# KITITAS COUNTY

## DEPARTMENT OF PUBLIC WORKS

SUBJECT: Suncadia Ph. 2 Div. 7 Tumble Creek LP-21-00002

SUNCADIA RESORT LLC
 PHASE 2 DIVISION 7
 COMPOSITE UTILITY PLAN
 WASHINGTON

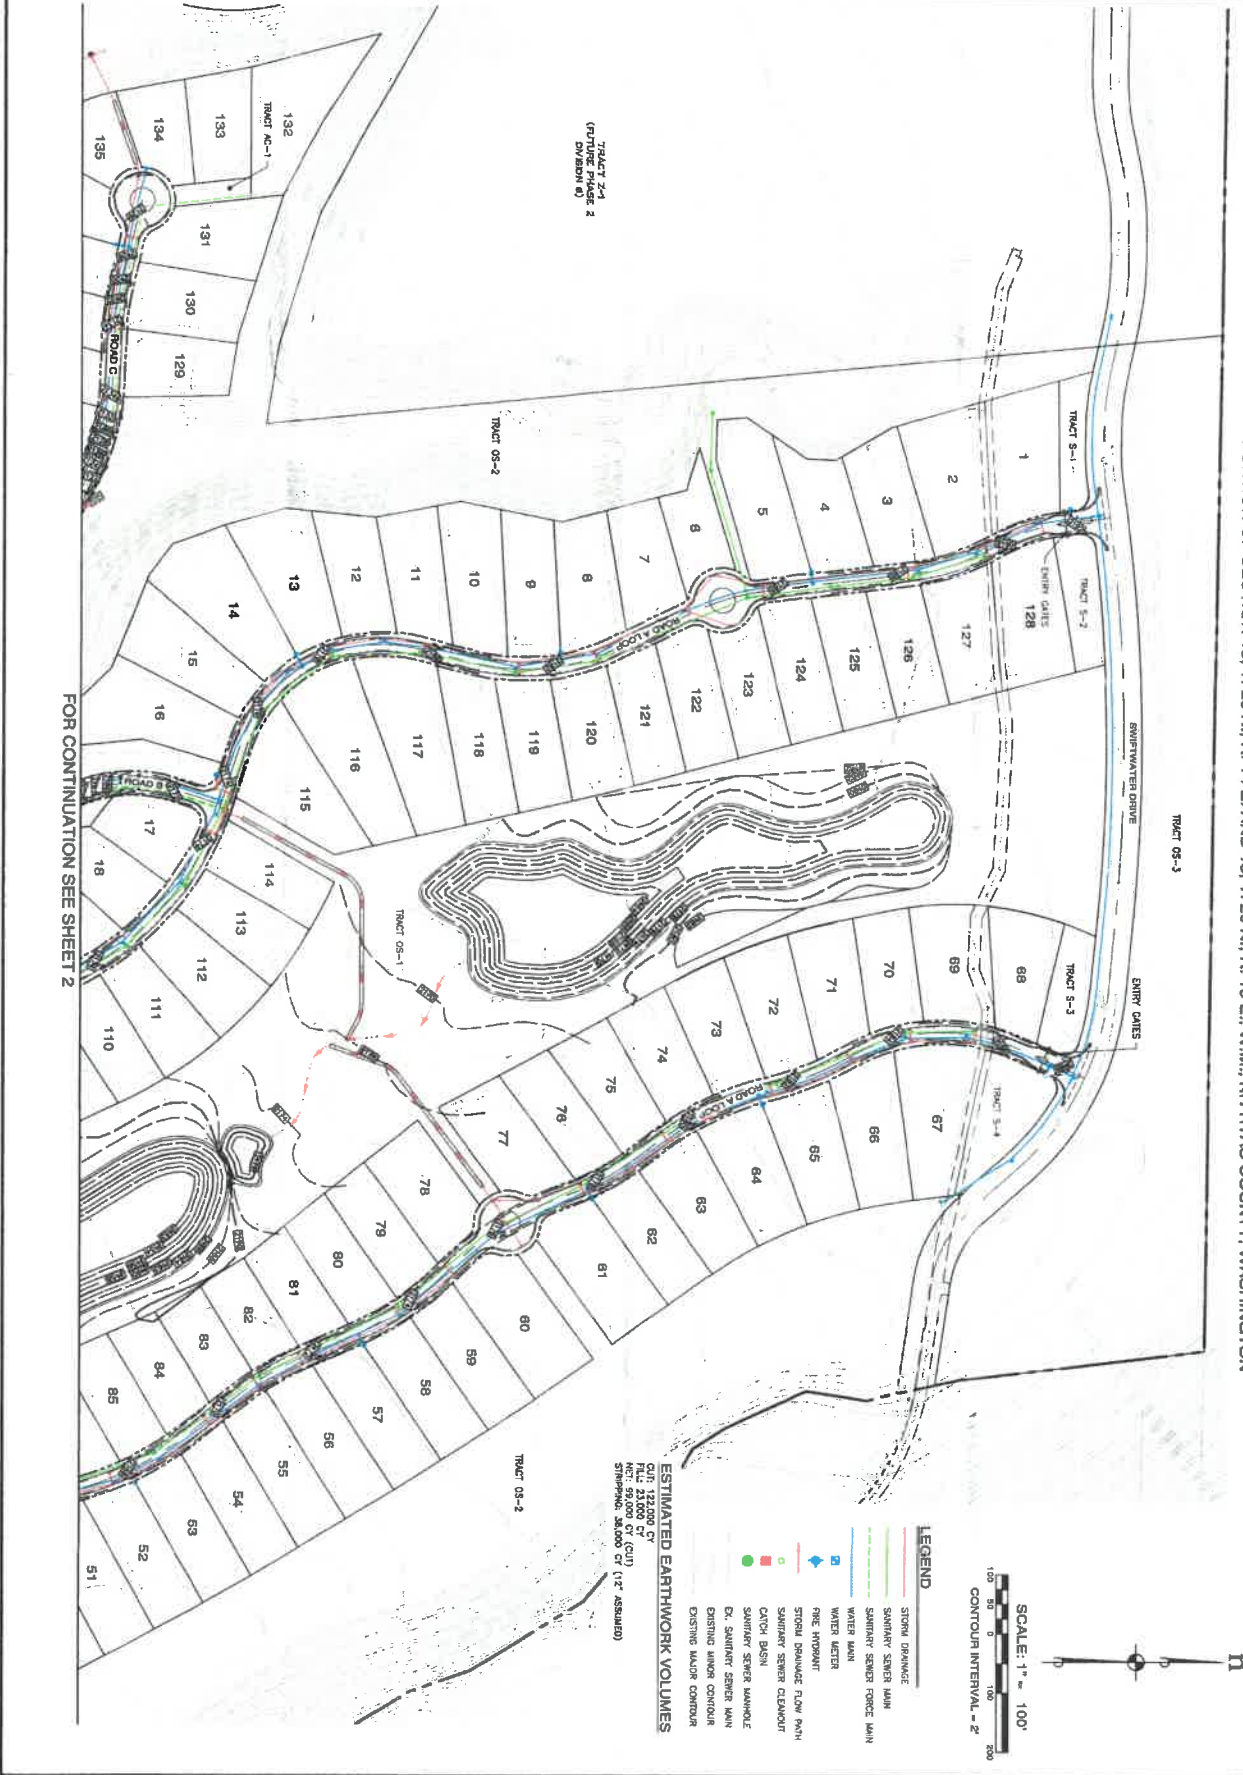
- Stormwater, please provide design calculations for treatment and disposal areas. If utilizing an existing system, please provide an accounting affirming sufficient capacity.
- While Suncadia is in the process of completing the Traffic Monitoring Plan, please submit an update report detailing what monitoring has been completed. This update report will be required for Final Plat.
- Please provide an inventory of equivalent residential units, or the accounting method utilized in the water system plan, affirming sufficient capacity serving the plat.
- Please provide an inventory of equivalent residential units, or the accounting method utilized in the general sewer plan, affirming sufficient capacity serving the plat.

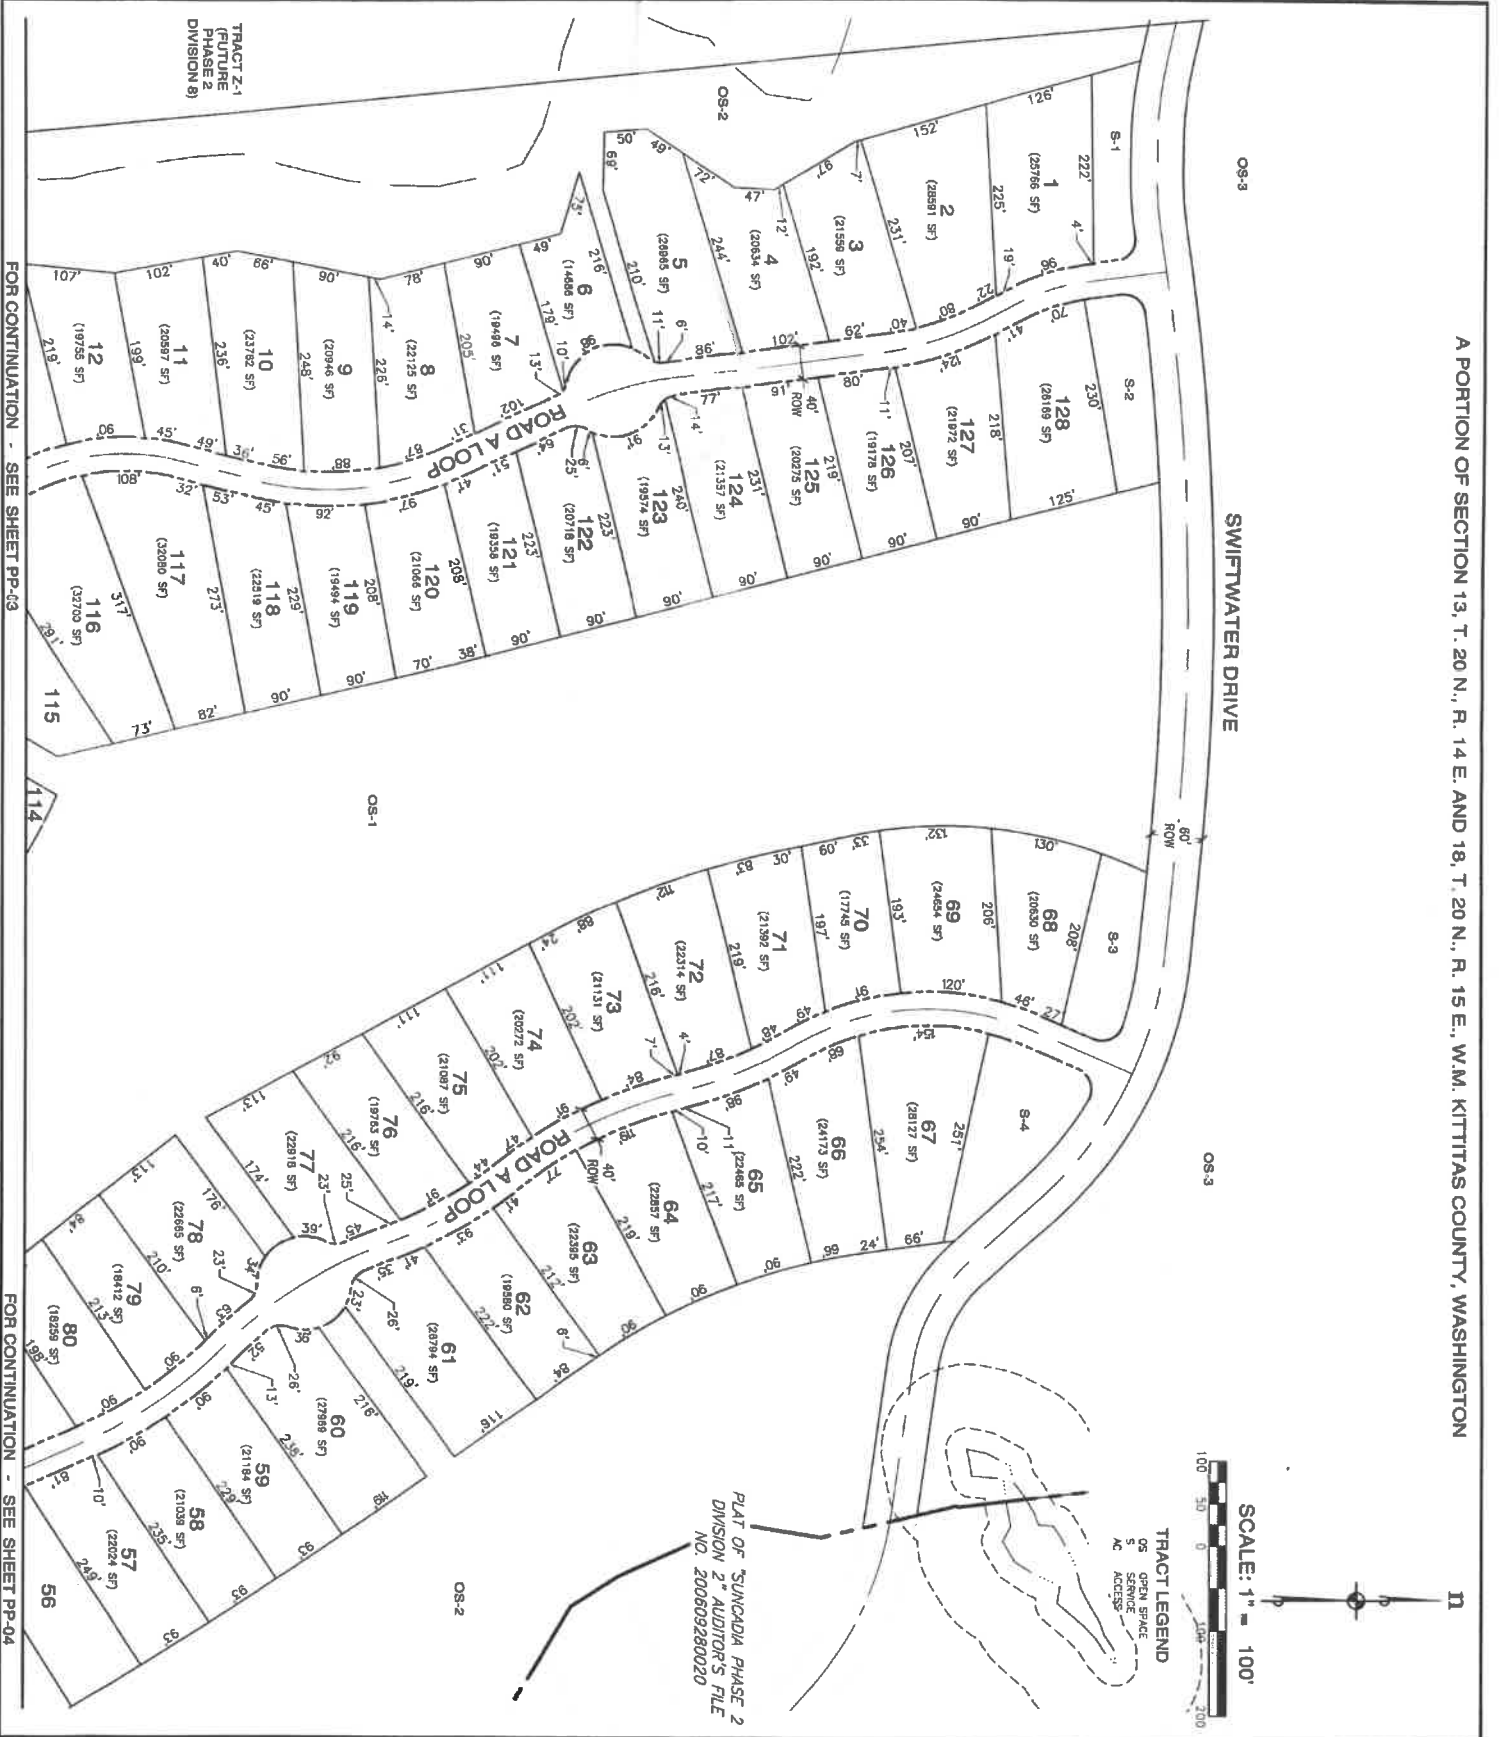
1. Please identify engineer and date of survey (KCC 16.12.020(5)).
2. Please show ownership, width and surfacing of existing roads (KCC 16.12.030(2)).

1. Per KCC 16.24.010 and .020 call for ties to survey monuments or section corners. As this particular area (Suncadia) has been incredibly well documented as to property ownership, there is no need to include this data on the Preliminary Plat. The Final Plat will need to show sufficient ties to controlling survey corners for intelligent interpretation and retracement of boundaries.
2. Per KCC 16.12.020 (3) Name of plat will need to be shown on the top and center of each sheet.
